Assessment of the CCR Compliance of the Tees Combined Cycle Power Plant Project

J.G. Yao, P.S. Fennell FIChemE, N. Mac Dowell FIChemE
Imperial College Consultants

Imperial College Consultants have reviewed a document provided by AECOM Consultants discussing the plant layout and equipment lists for potential carbon capture and storage (CCS) options for Sembcorp Utilities (UK) Limited's Tees Combined Cycle Power Plant Project to evaluate whether the proposed plans are compliant with the UK DECC (now BEIS)'s Carbon Capture Readiness (CCR) Guidance as amended by the Imperial College Assessment (Florin and Fennell, 2010).

Figure 1 - Tees CCPP High Level Layout

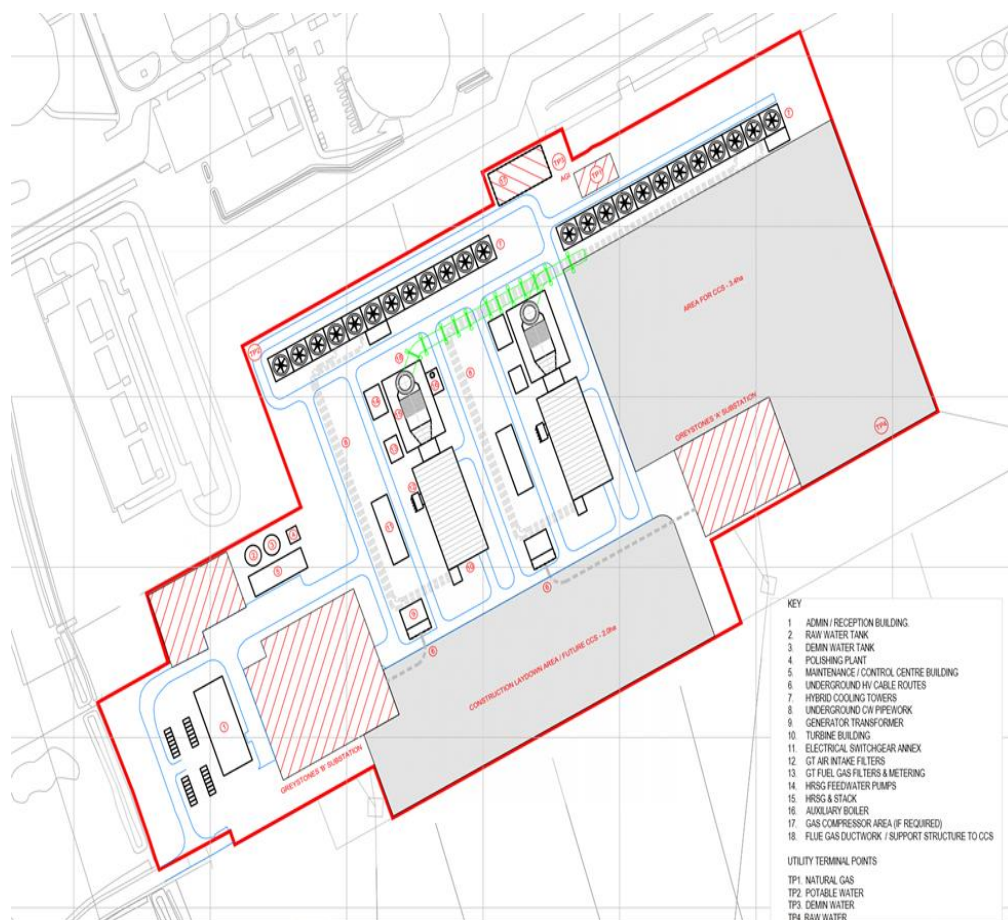
The project plant layout is based on a “worst case scenario” estimate which assumes all heat exchangers will be air cooled. If hybrid cooling is used, the footprint of the plant should decrease.

It is reasonable that the control systems and administration are moved to be within the footprint of the power plant. Modern plant control / monitoring is increasingly non local.

Based on the turbine efficiency study carried out by AECOM, it is clear that class H turbines are required to fit the CCGTs to the allocated area. If class F and E turbines were used, the required specific area will increase to 51.3 and 63.3 m²/MWe, respectively.
